Consultation Response (Biodiversity)

<i>Discharge of Conditions consultation response</i>		For office use
Date of response	05/11/2018	<i>Is this a response to an informal consultation request?</i> Yes ☐ No ☒
Location	Adj, 106, Royd Street, Milnsbridge, Huddersfield, HD3 4RB	
Application number	2018_93395	
Responding officer	Tom Stephenson

PROPOSED FRONT ELEVATION (FROM ROYD STREET)
SCALE 1:100 AT A3

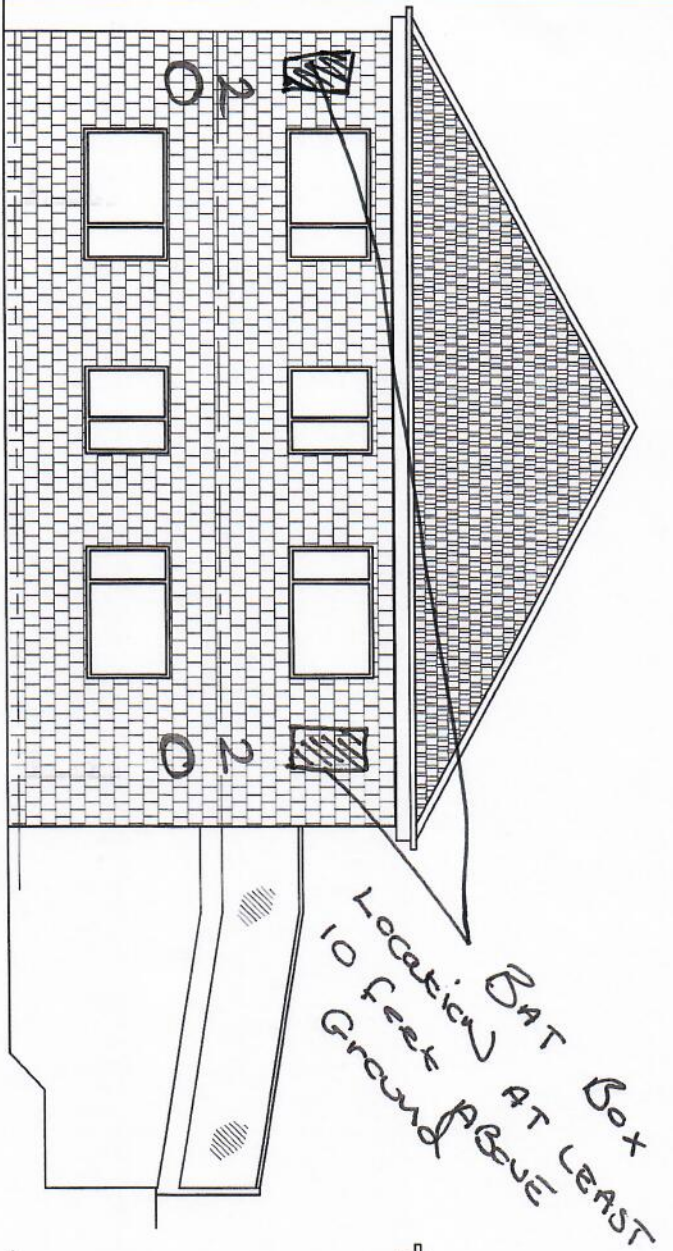
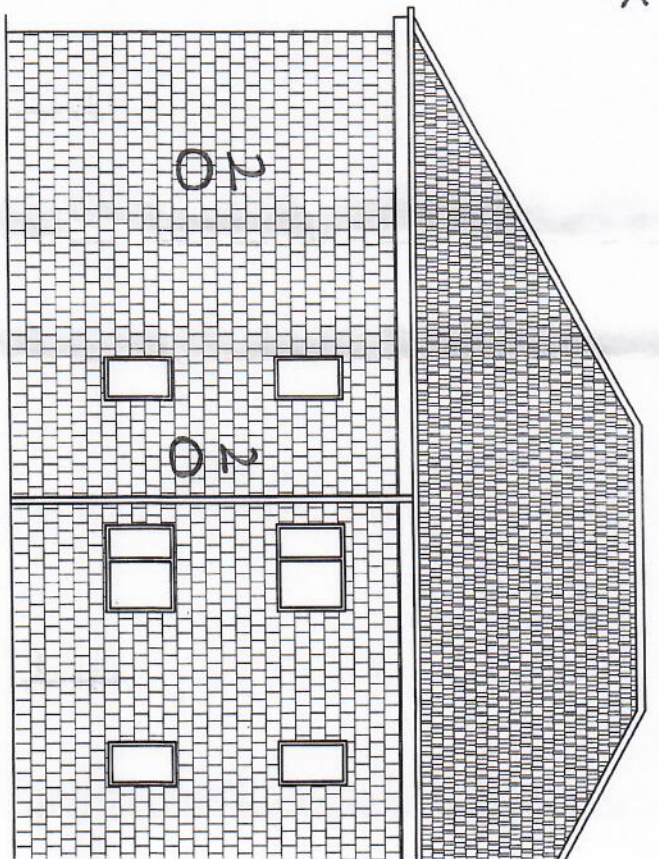
The proposed lighting will need to take account of the location of the bat box required under condition 7, i.e. an unlit corridor should be provided that allows bats to access to and from foraging areas. Can the applicant indicate where this has been/will be installed?

With regards to the proposed lighting, lighting in the soffits may be incompatible with use of the site by bats, but I will make this assessment following confirmation of the location of the bat box.

Based on the available information I cannot recommend that condition 8 is discharged.
